Re: Moorebank Precinct East – Stage 2 - Mod 1 SSD 7628

Council has engaged Cardno to review the application on behalf of Council and to provide the following submission.

Council have reviewed the exhibited EIS and Plans and make the following comments:

Figure 7 | Examples of warehouse identification signage (Source: Applicant's MOD 1 Modification Report)

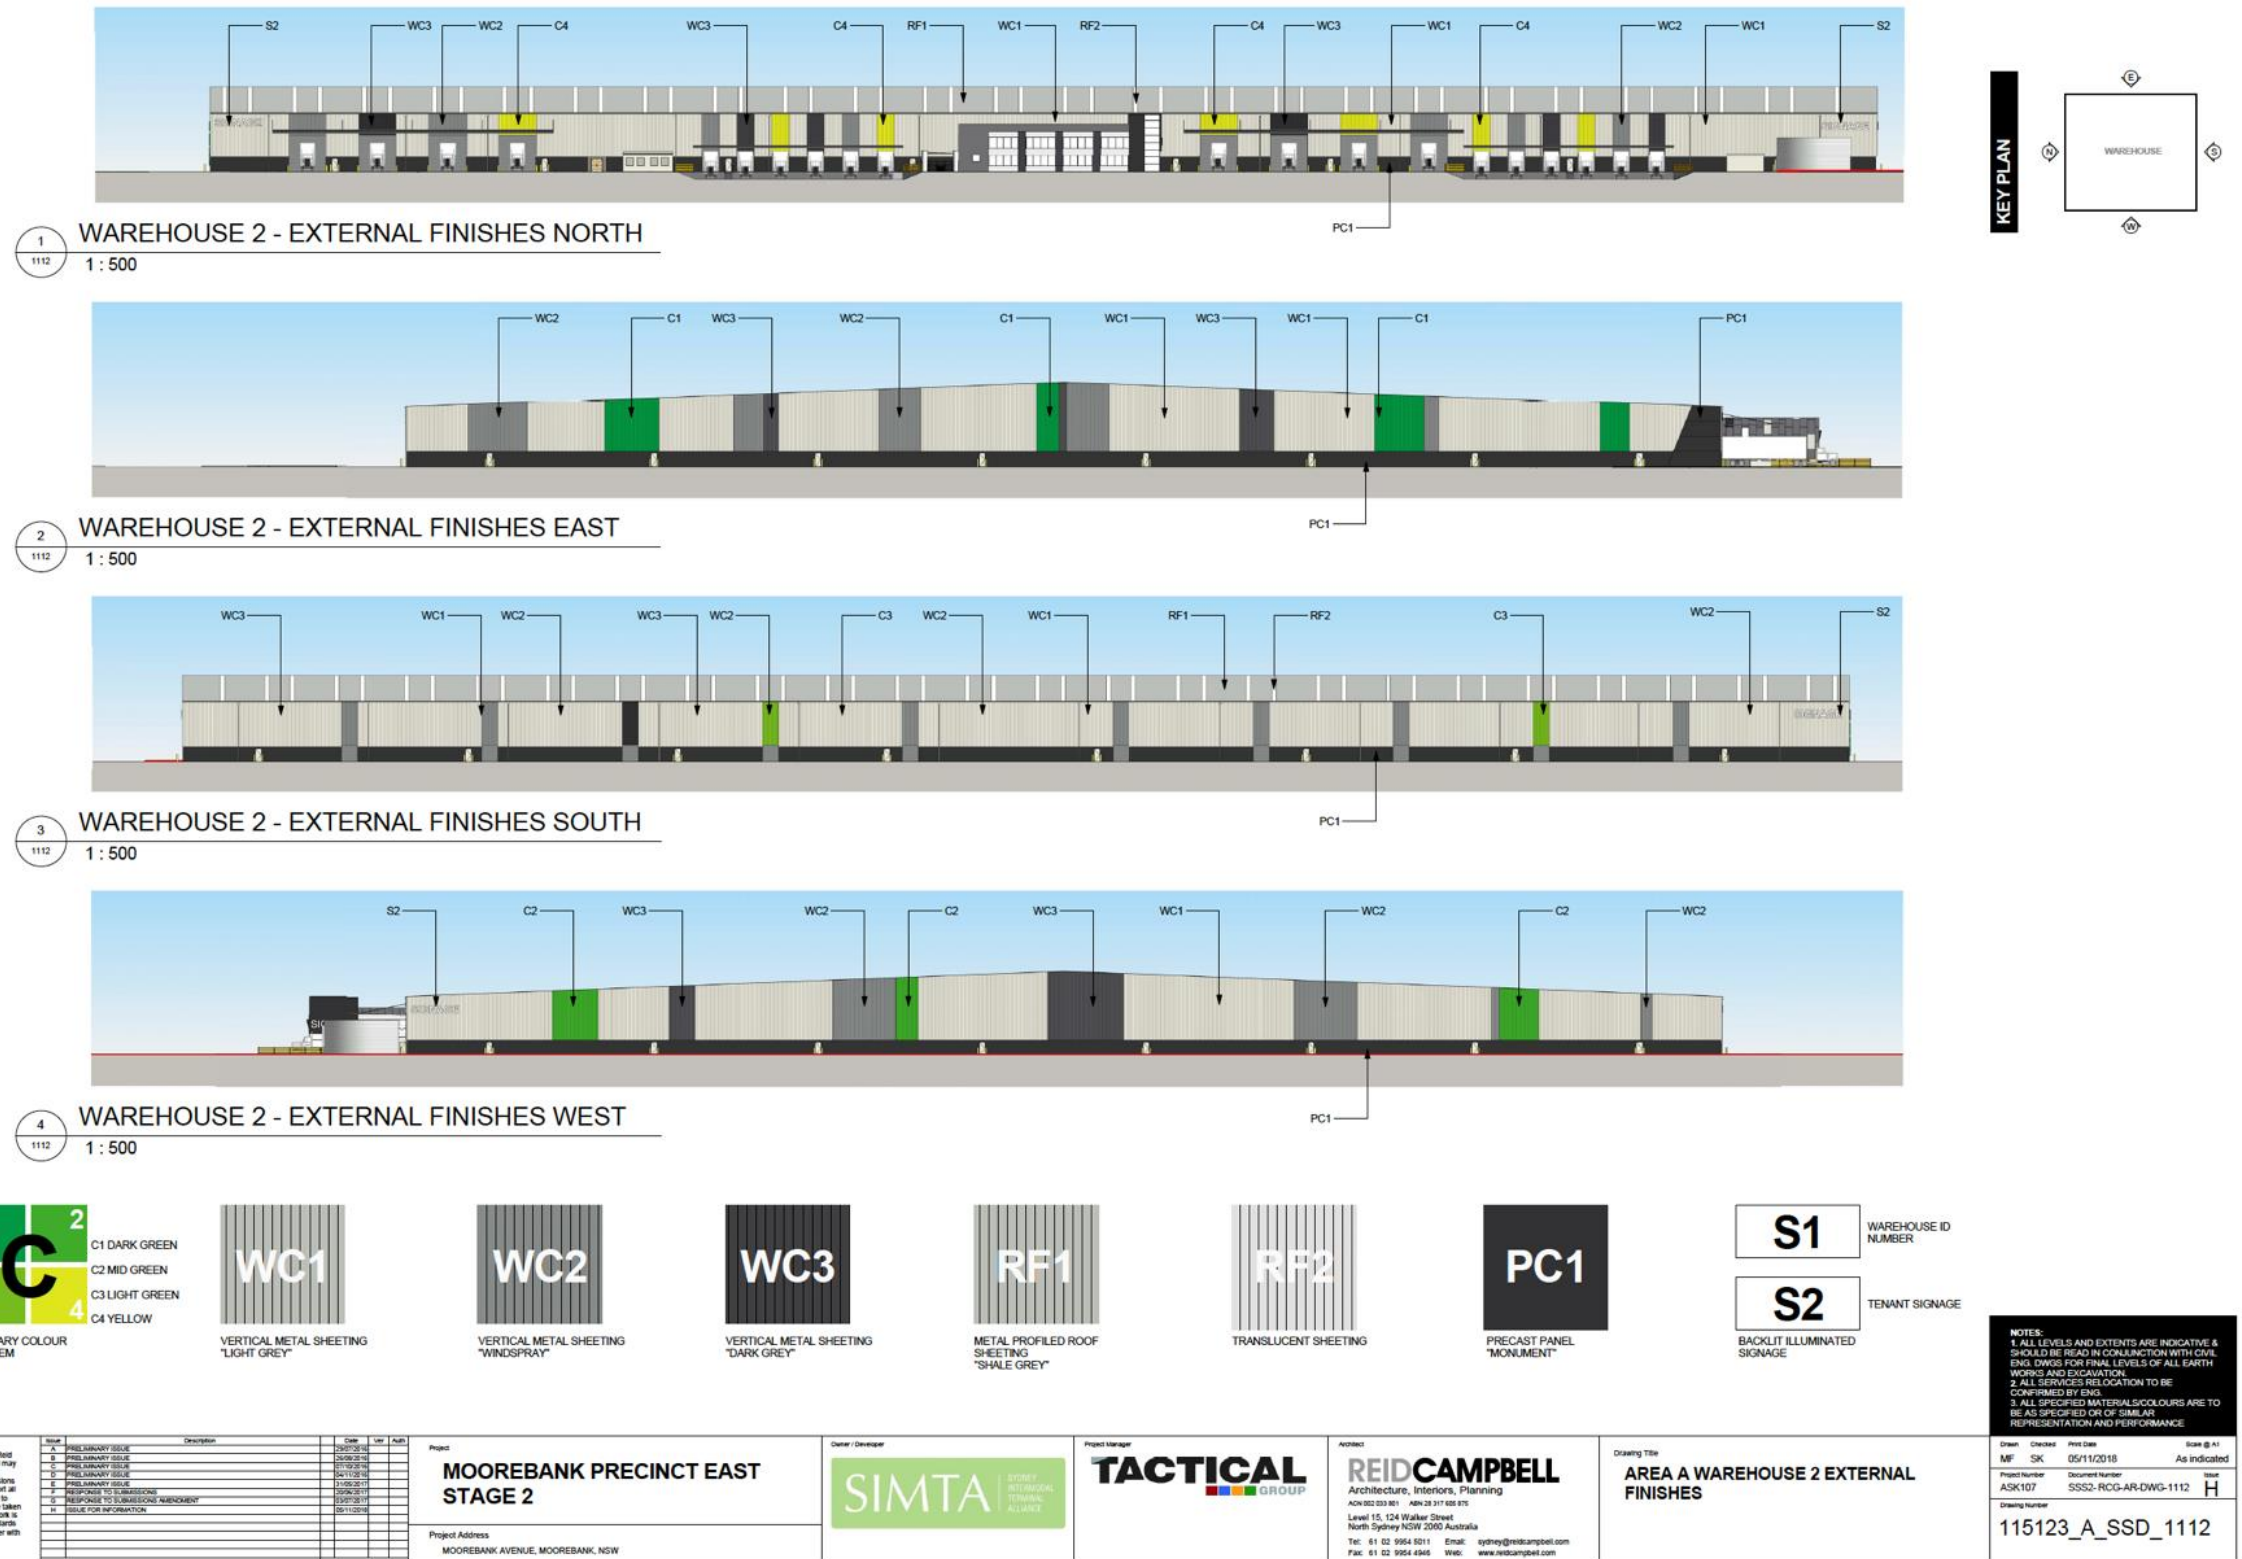
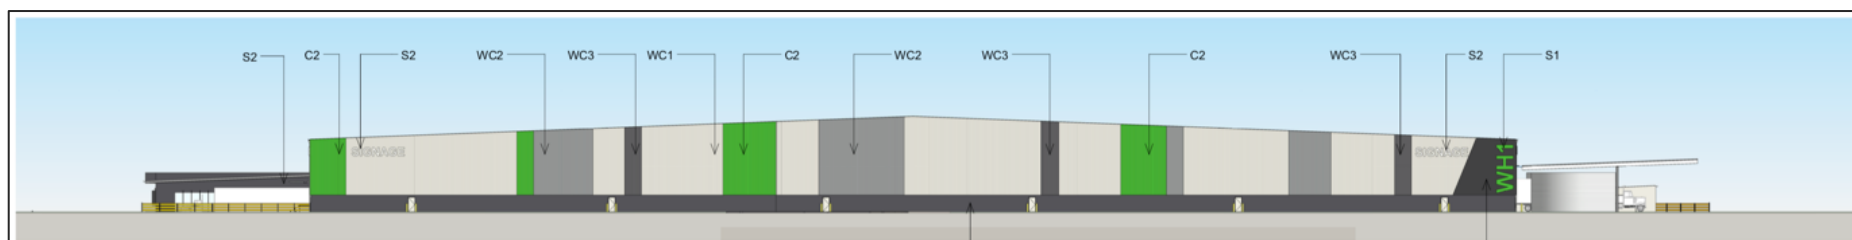
Deletion of Condition B141(f) (ii) – Council accepts that the 3m height limit is onerous and notes from the submitted elevations that the majority of proposed signage sits well under the main parapet of the buildings. The exception is the vertical signage on the Freight Village. In this regard, Council requests that a visual impact assessment of the vertical signage on the Freight Village be undertaken.

Revision of Condition B141(f)(v) – Council have reviewed the submitted plans and elevations and are satisfied with this proposed modification as all illuminated signage appears to be oriented towards the internal areas of the site or screened by vegetation with the possible exception of the Freight Village signage.

Revision of Condition B141(f)(viii) – Similarly, Council raises no objection provided a visual impact assessment is undertaken of the vertical signage on the Freight Village.
